## **A46 Newark Bypass – Development Consent Order (DCO) Application**

### **A46 from Farndon Roundabout to Winthorpe Roundabout, near Newark-On-Trent**

#### **Deadline 2 (12 November 2024) – Written Representations**

ORIGINAL SIZE	A3	SCALE	1:20,000	PROJECT REF NO.	HE551478
DRAWING NUMBER	HE551478	ORIGINATOR	SKAG	VOLUME	EGN
LOCATION	CONWI_CONW	DR	LE	00008	REVISION
		TYPE	ROLE	NUMBER	C01

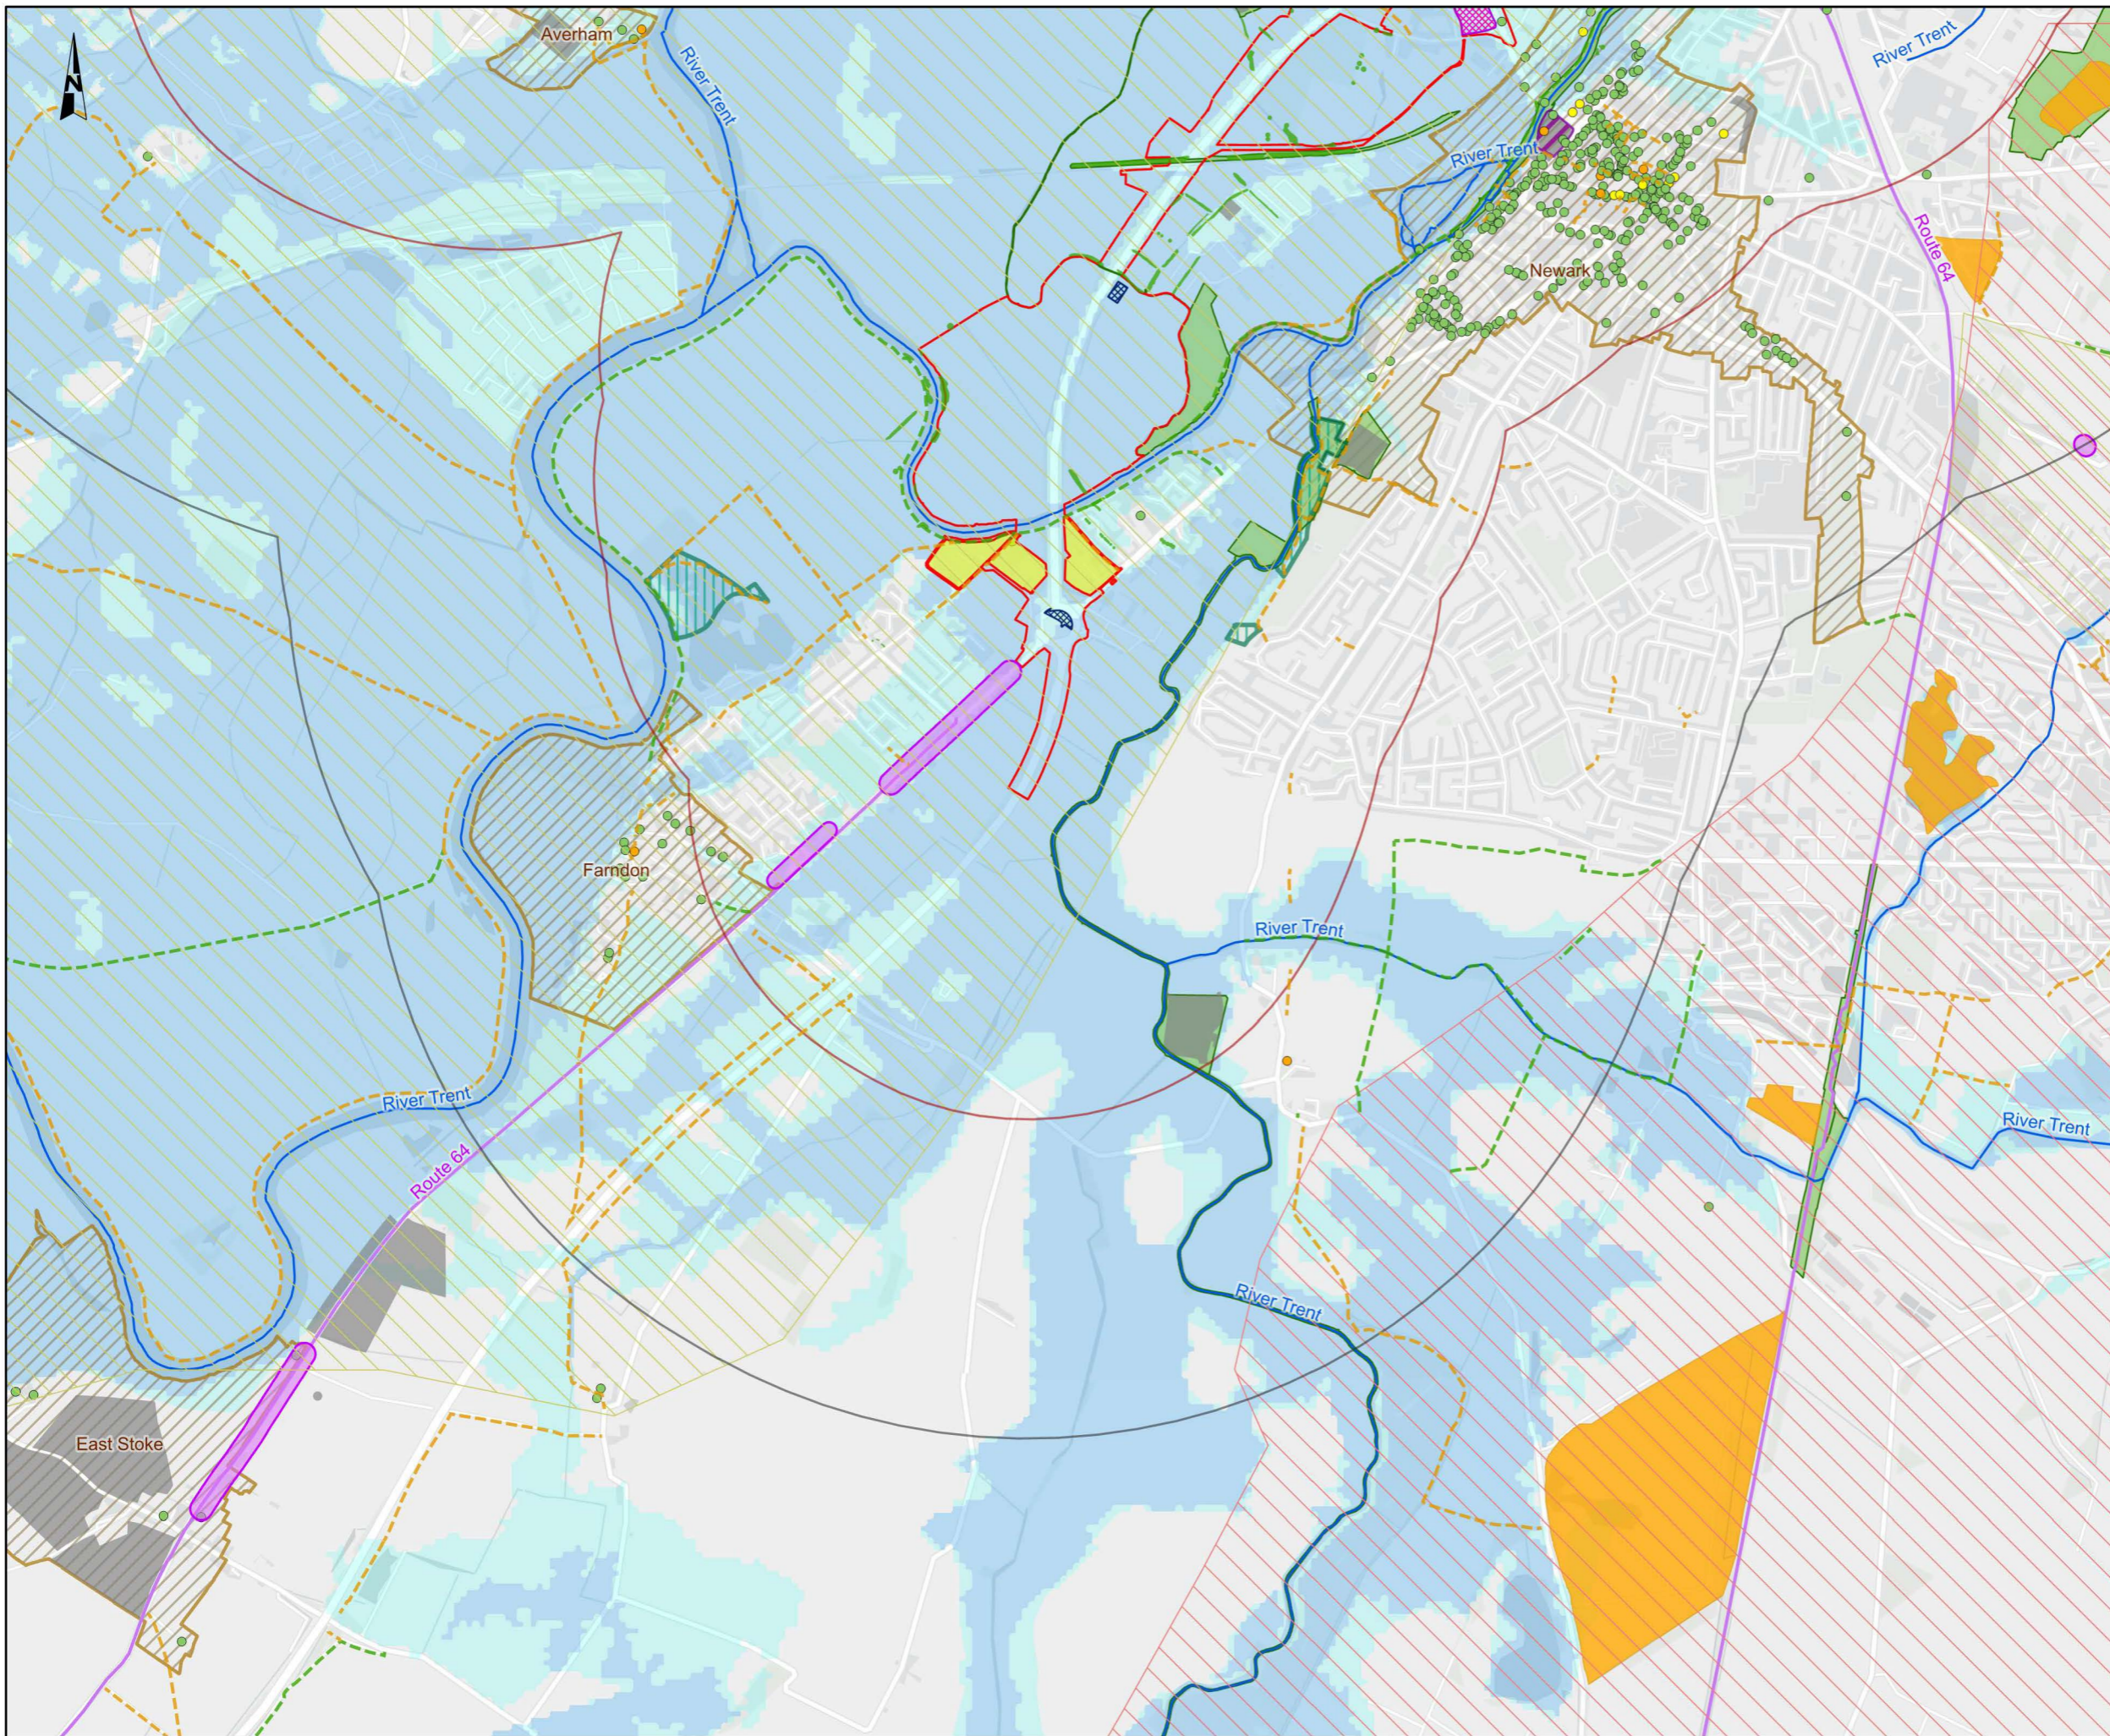
- **Contaminated land assessment**  
We are awaiting an updated Environmental Constraints Plan to be submitted at Deadline 2 in relation to issue EAGWCL-001 (British Sugar authorised (active) landfill site), and the submission of a Detailed Quantitative Risk Assessment (DQRA) and agreement of a satisfactory approach to addressing the contamination hotspot at WS46 (issue ref. EAGWCL-005).
